SECOND CHANGE APPLICATION REPORT

Drax Bioenergy with Carbon Capture and Storage

Document Reference Number: 8.15

Applicant: Drax Power Limited

### Proposed Changes to Land Plans for OHL1

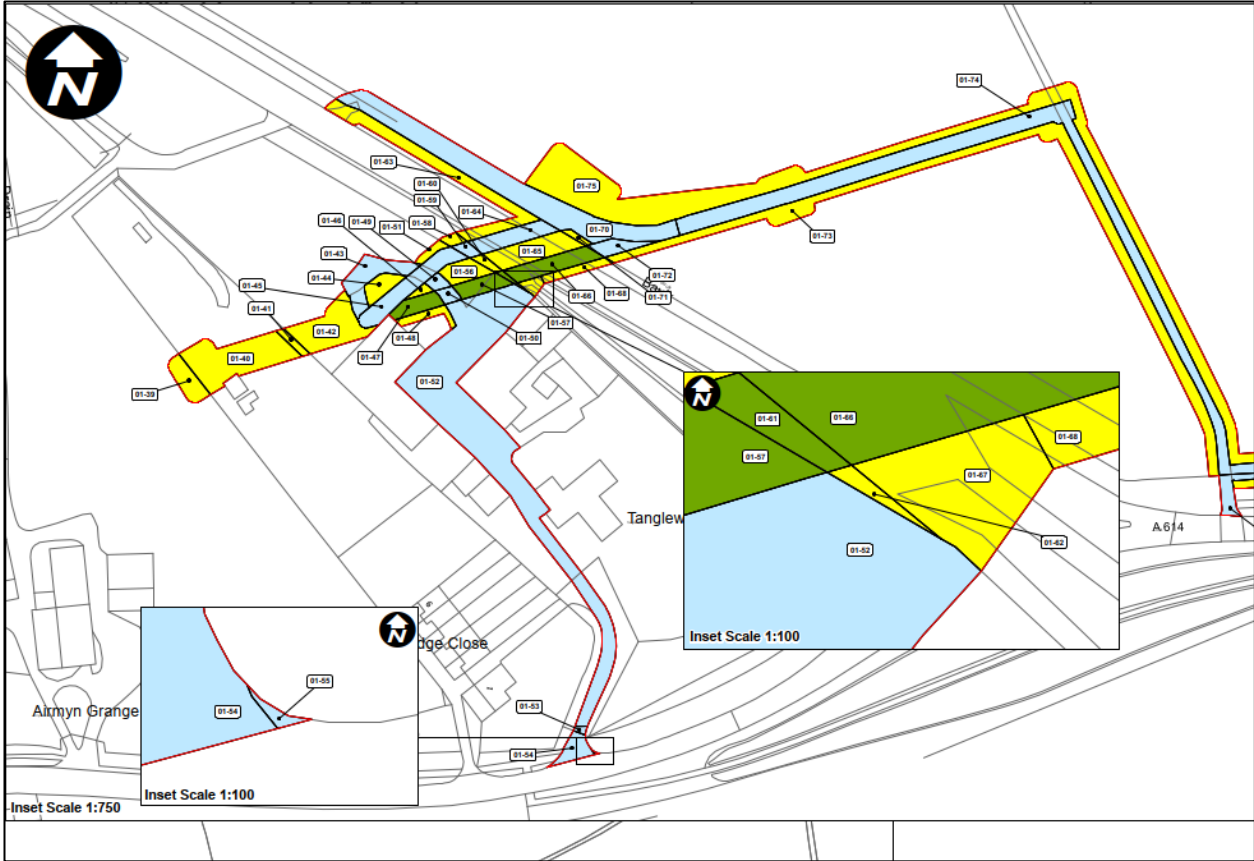
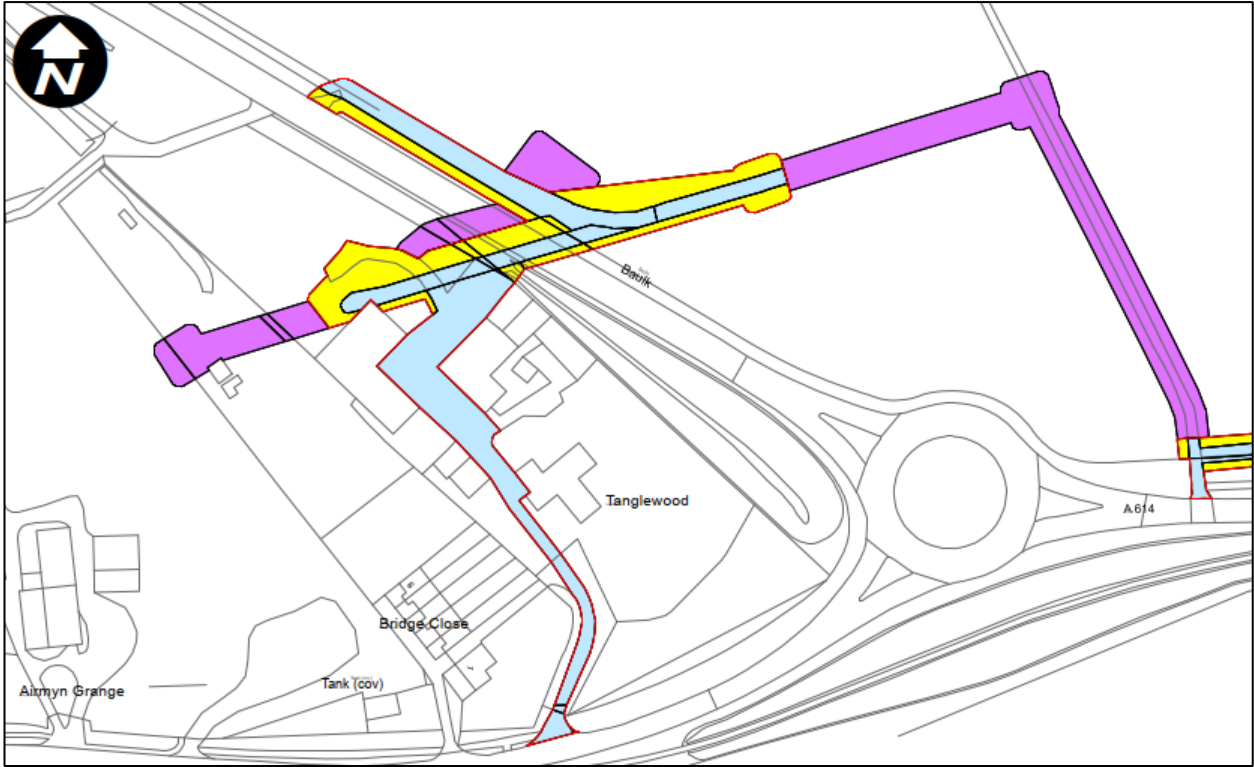
- 2.2.1. OHL1 is an existing electrical overhead line which crosses the A645. Sheet 3 of the Land Plans shows the areas of land affected by works for OHL1 (west and east of the A645). Below are extracts from the currently submitted Land Plans and extracts illustrating the proposed changes. The land identified in purple is no longer required for works and it is proposed to remove this land from the Order Limits. It can also be seen that the areas of land previously proposed to be subject only to extinguishment of rights powers, is now sought to be subject to compulsory acquisition of rights powers.

- 2.3.1. The asset owner, Northern Powergrid’s preferred design for the works has confirmed that undergrounding via a trenchless installation method such as Horizontal Directional Drilling (HDD) is not feasible due to other utility assets in the locality, and that the installation of the undergrounded section of the electrical cable would be via an open trench installation method across the highway only. The asset owner has confirmed that it would prefer to retain the overhead line in its current alignment with the only undergrounded section being across the highway also following the alignment of the existing overhead line within a 10m wide corridor to provide flexibility to adjust the exact routing to navigate around existing infrastructure in/under the

highway. To facilitate this solution, it is proposed that a new wooden pole is installed on the eastern side of the A645, within the verge or as close to the edge of the field as possible, and the overhead line restrung from this new pole to the existing next wooden pole in the line, immediately to the east. This solution means that the works required on land to the east of the A645 for OHL1 (owned by ERYC and currently occupied by Mr Roustoby) are limited to:

- 2.3.3. There is no longer a need for land to accommodate the HDD/works compound on the eastern side of the A645, or a requirement to use the existing farm access track from the A614 to facilitate access to existing wooden poles for restrung purposes for OHL1, and therefore these areas of land will be removed from the Order Limits.

- 2.3.4. On land to the west of the A645, the asset owner has confirmed it would prefer to remove the existing wooden pole located immediately to the west of the A645, install a new wooden pole in the same location, and the undergrounded section under the A645 would then end and continue along its existing alignment with a restrung section of overhead line to the next existing wooden pole in the line, immediately to the west. This solution means that the works required on land to the west of the A645 are limited to land owned by Mr Hussain (Tanglewood), and after the installation works described above are completed, the electricity asset would appear very similar to the existing design, with temporary rights of access required to undertake the works, and permanent rights required to facilitate access to, and to maintain and repair the electricity asset in perpetuity.

## Proposed Changes to Land Plans for TCL1

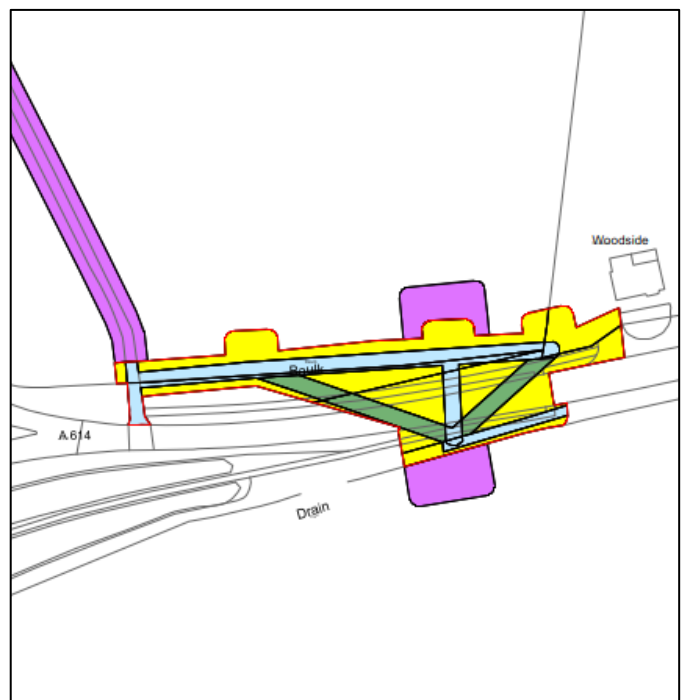
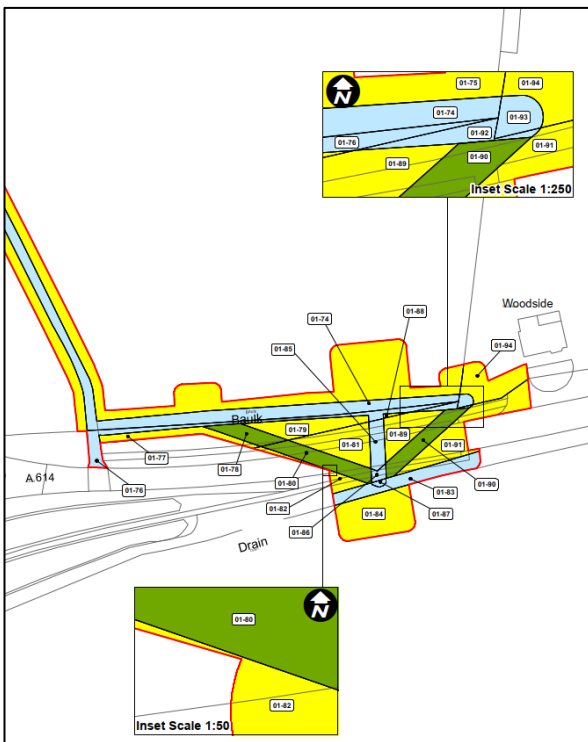
2.2.2. TCL1 is an existing telecommunications line which crosses the A614 twice to the west of Woodside Café. Sheet 3 shows the areas of land affected by works for TCL1 (north and south of Rawcliffe Road). Below are extracts from the currently submitted Land Plans and extracts illustrating the proposed changes. The land identified in purple is no longer required for works and it is proposed to remove this land from the Order Limits. It can also be seen that part of the areas of land previously proposed to be subject only to extinguishment of rights powers, is now sought to be subject to compulsory acquisition of rights powers.

- 2.3.7. The asset owner, BT Openreach, has confirmed that its preferred design to remove conflict with the AIL deliveries would not be to underground the telecommunications line, but instead to replace the existing wooden pole on the southern side of Rawcliffe Road with a taller pole (15m high), install a new wooden pole 15m high on the northern side of Rawcliffe Road opposite the aforementioned pole, and provide a continuous telecommunications line connection between the existing wooden poles immediately to the east of the farm track on the northern side of Rawcliffe Road, on to the new 15m high pole and onwards to the existing wooden pole at the south-western corner of the Woodside Café. The existing telecommunications lines crossing the A614 would be removed, and a new line installed between the two 15m high poles, resulting in the line crossing the A614 once.

- 2.3.8. This solution means that the works required on land to the east of the A645 and north of the A614 for TCL1 (owned by ERYC and currently occupied by Mr Cowling) are limited to:

- 2.3.10. There is no longer a need for land to accommodate the HDD/works compound on the northern and southern sides of the A614 and therefore these areas of land will be removed from the Order Limits.
